Rezoning Transportation Analysis
Petition Number: Insert Zoning Petition # 2021-007
General Location Identifier: Tax ID 08113110

Revision Log:	Date	Description
	03-25-2021	First Review (WB)
	04-25-2021	Second Review (WB)
	05-27-2021	Third Review (KP)

SITE PLAN

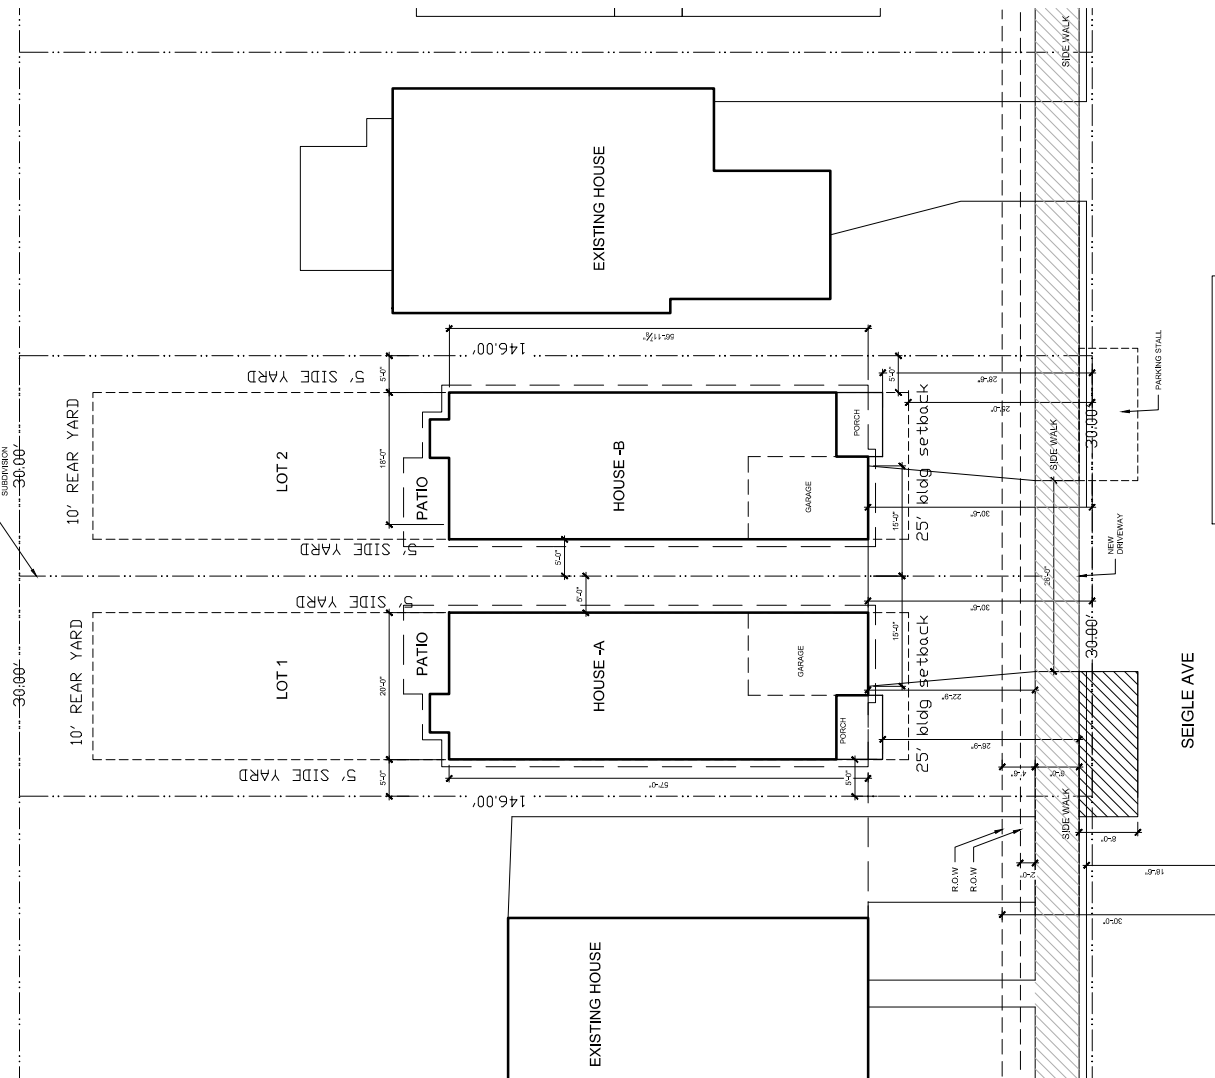
1. ~~**Curblines:** The proposed zoning district has a setback measured from back of the existing or proposed future curblines.~~
 - a. ~~**Seigle Avenue:** Location of curb and gutter needs to be constructed at 18.5' from the road centerline removing the existing on-street parking along the site's frontage.~~

~~Label and dimension the curb and gutter from the centerline for each road on the site plan.~~

3. ~~Revise site plan and conditional note(s) to commit to dedicate 30' min right-of-way from the road centerline. The site plan shall label and dimension the right-of-way from the road centerline. Clearly label the proposed ROW as 'dedicated' to differentiating between the existing and the proposed ROW.~~ **REVISED based on updated plan 4/19/2021**

4. ~~Revise site plan and conditional note(s) to commit to construct a 6-foot sidewalk, and an 8-foot planting strip on Seigle Avenue. The site plan shall label and dimension both items from the back of curb and gutter and road centerline.~~

~~Reference CLDSM standard detail 11.09 for street typical.~~ **RESOLVED 4/19/2021**

7. ~~There are two on-street parking spaces located in front of property. Update the site plan to show the location of the on-street parallel parking spaces in front of the site on Seigle Avenue.~~ **RESOLVED 4/19/2021**

8. ~~Add a site plan note specifying that all transportation improvements will be approved and constructed before the site's first building certificate of occupancy is issued is needed. The petitioner may phase transportation improvements if said improvements and phasing are explicitly described in site plan notes.~~ **RESOLVED 4/19/2021**
